CITY OF ALBUQUERQUE

January 19, 2018

**RE: Coors Pavilion Lot 4 (Panera Bread)
9154 Coors Blvd
Request for Certificate of Occupancy
Hydrology Final Inspection- Not Approved
Engineer's Stamp Date: 5/31/17 (G11D069A)
Certification Dated: 1/16/18**

LOT 4  
SITE UTILITY PLAN

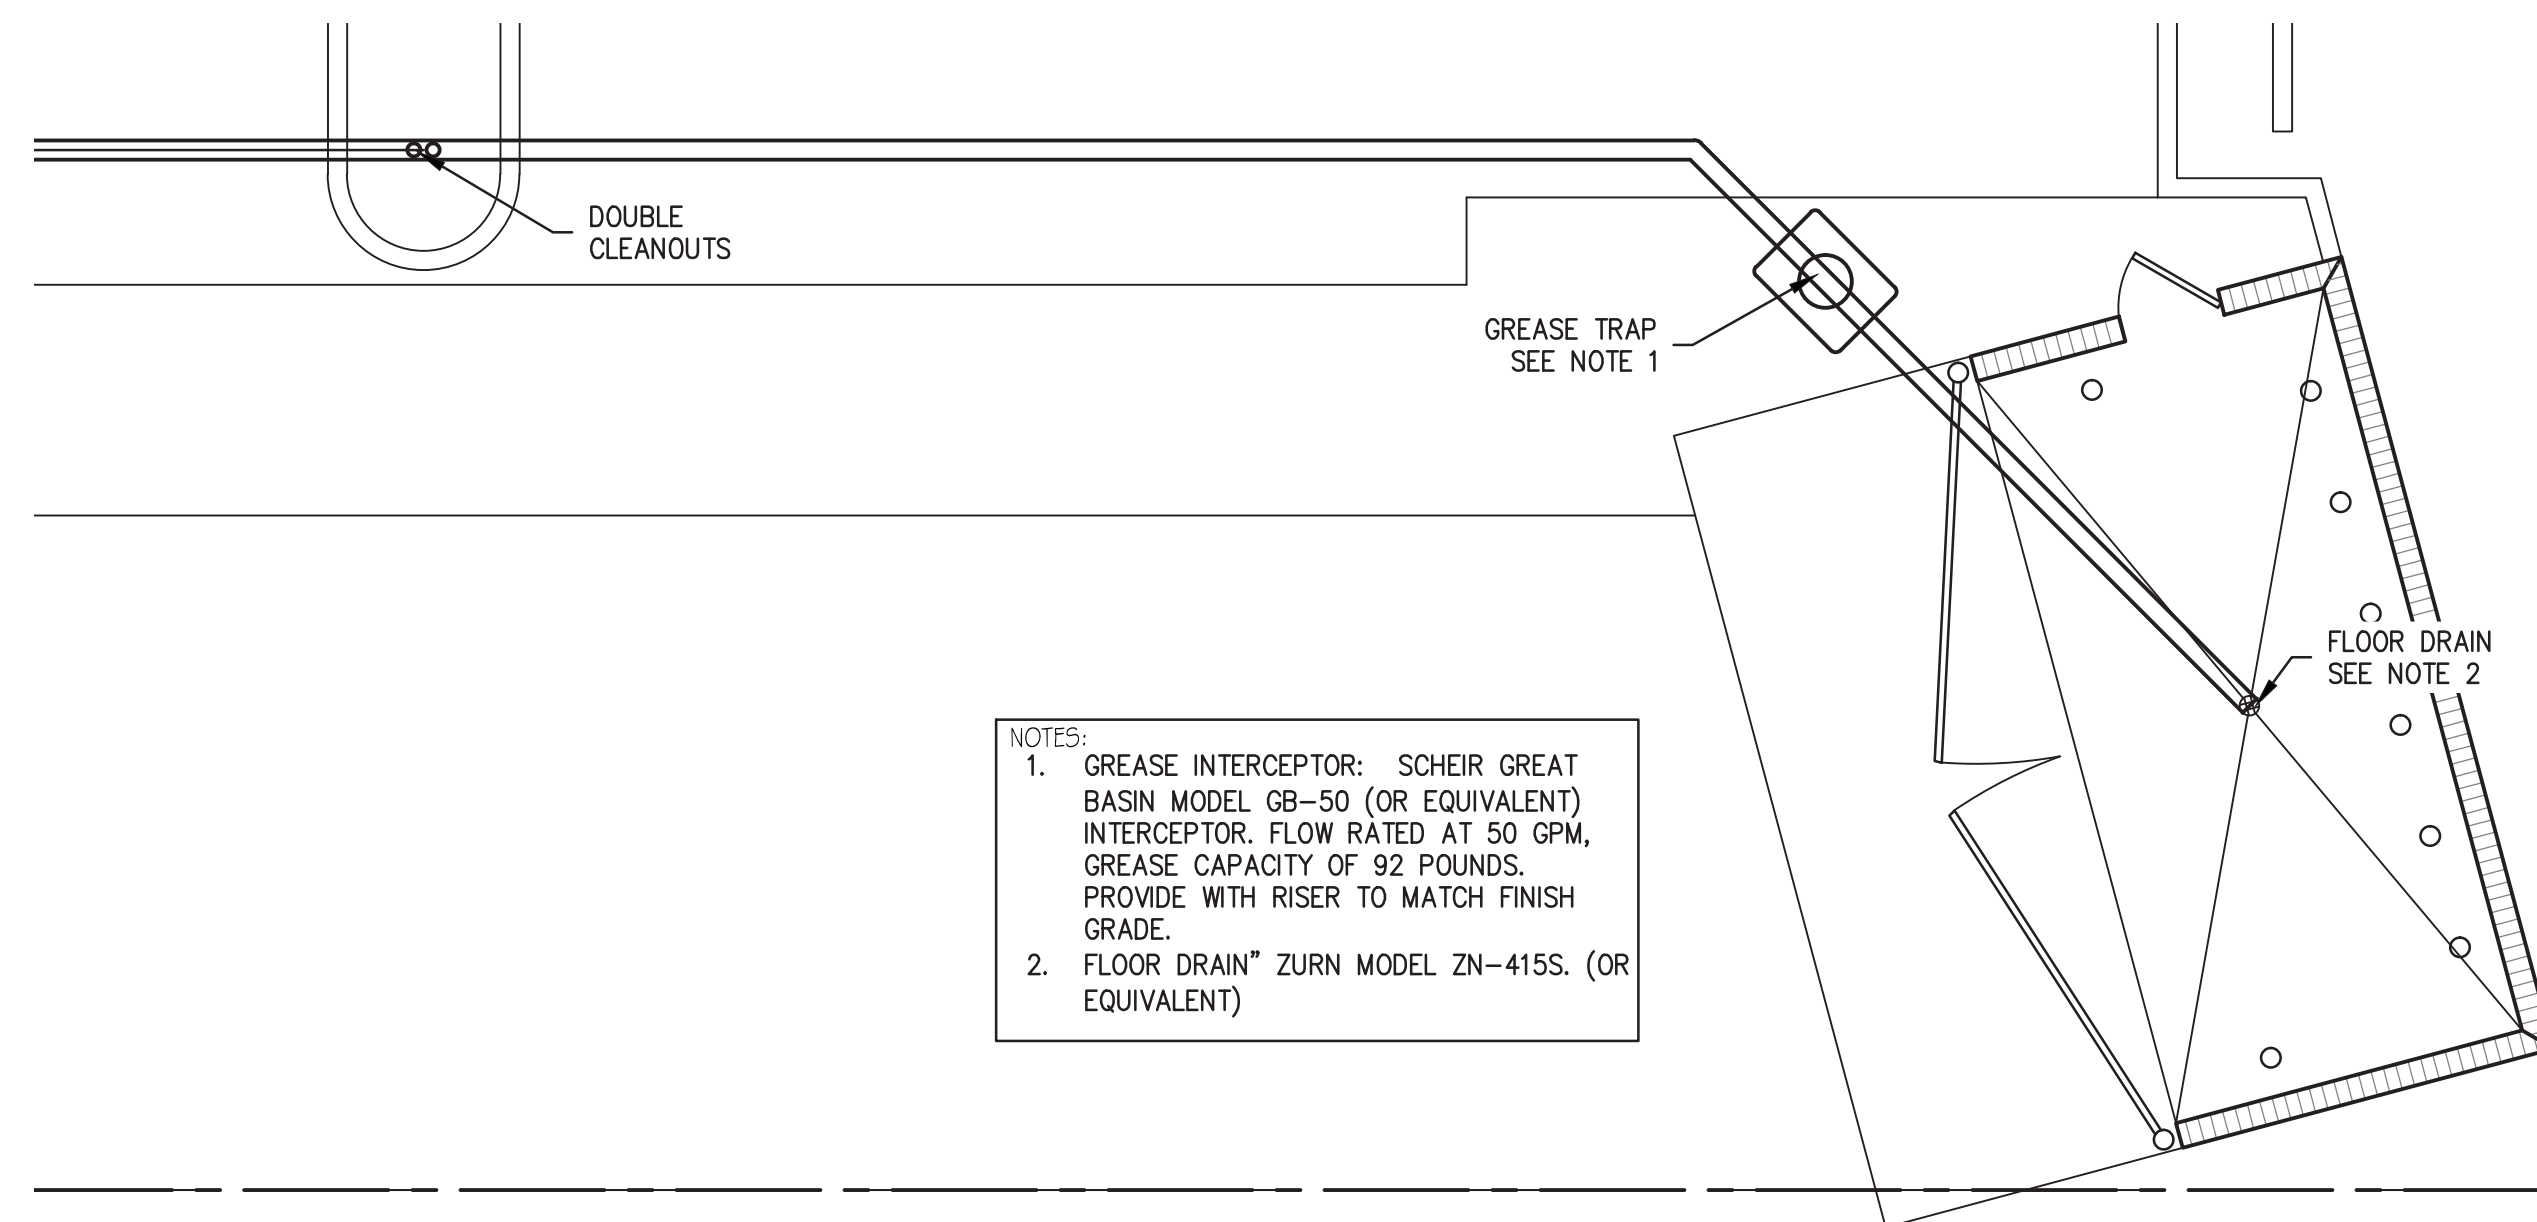
1. The ¾" steel rods welded to the street side of the sidewalk culvert need to be ground flush and smooth with the face of curb. Once complete, provide photo of the corrected culverts.
2. The small first flush pond in the NW corner is smaller than shown on the approved Grading Plan. The new pond size needs to be shown on the drainage certification, along with its new volume and elevations.
3. Please include the utility sheet, showing the location of the grease trap and drainline from the dumpster with your resubmittal.
